# Advice to decision maker on coal mining project

Requesting agencies	The Australian Government Department of the Environment and Energy The New South Wales Department of Planning and Environment
Date of request	23 March 2017
Date request accepted	28 March 2017
Advice stage	Assessment

### IESC 2017-083: Hume Coal Project (EPBC 2015/7526) – New Development

Figure 6.6.
Differential drawdown of the water table at 17 years since the start of mining.

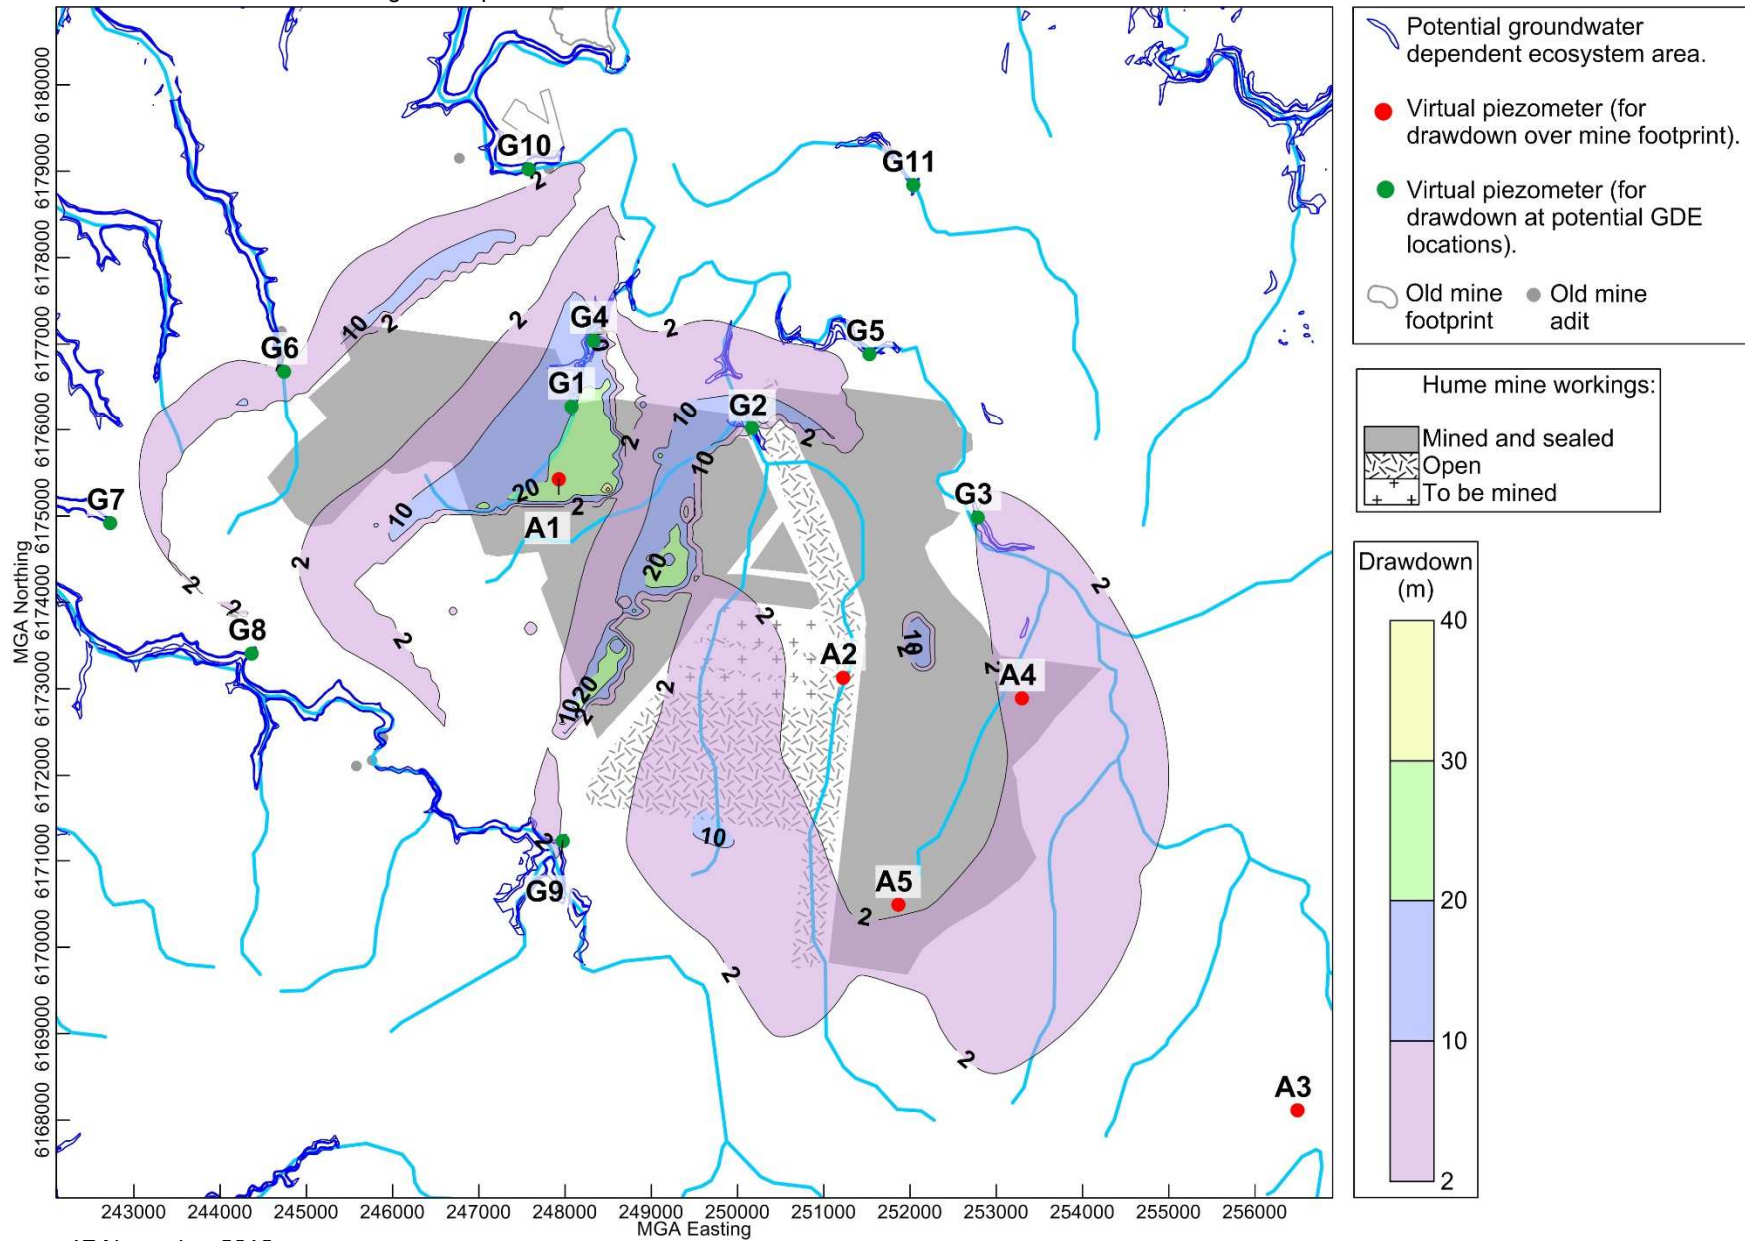
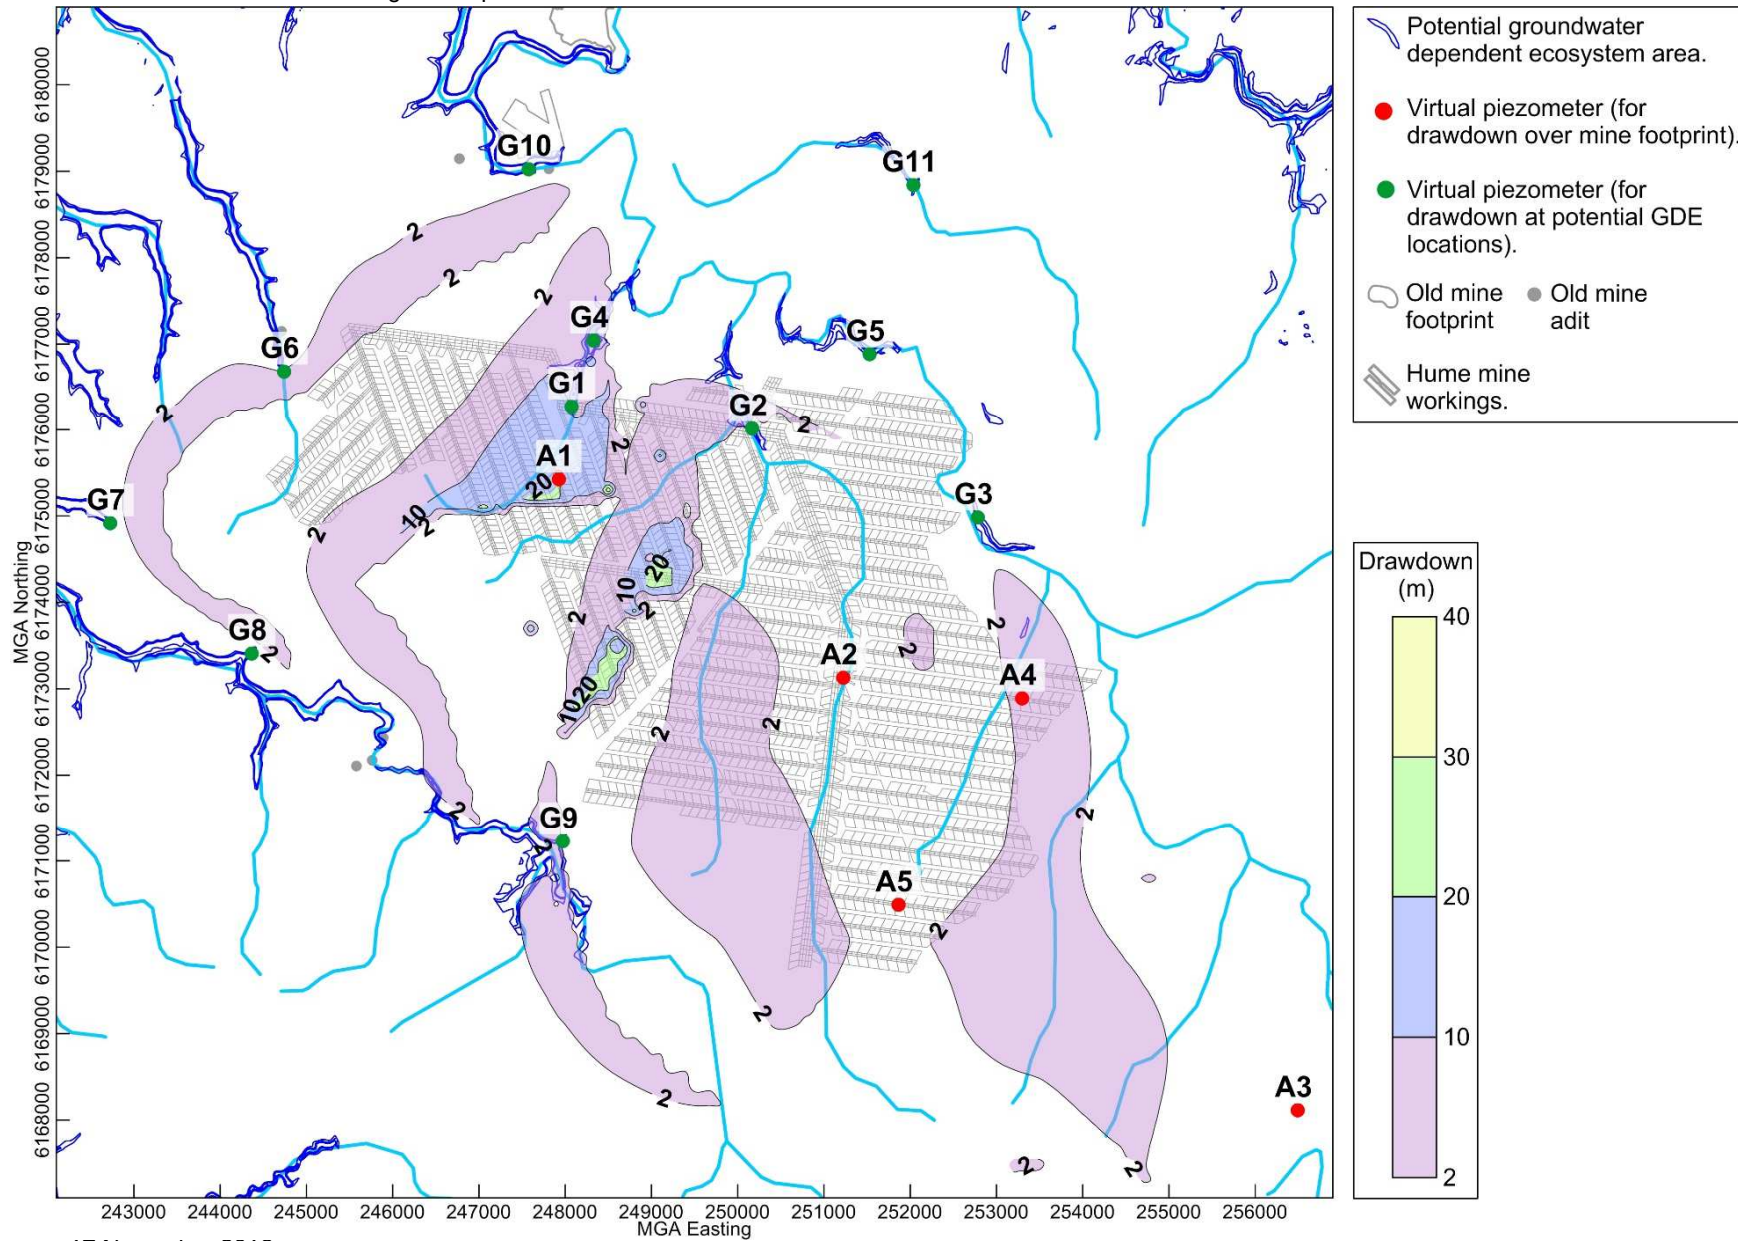
- c. Predicted drawdown in all layers at multiple stages of the project including earlier in the operation, 17 years, 30 years (for consistency with water table prediction maps already presented) and additional post closure time periods to show the rate of groundwater recovery.
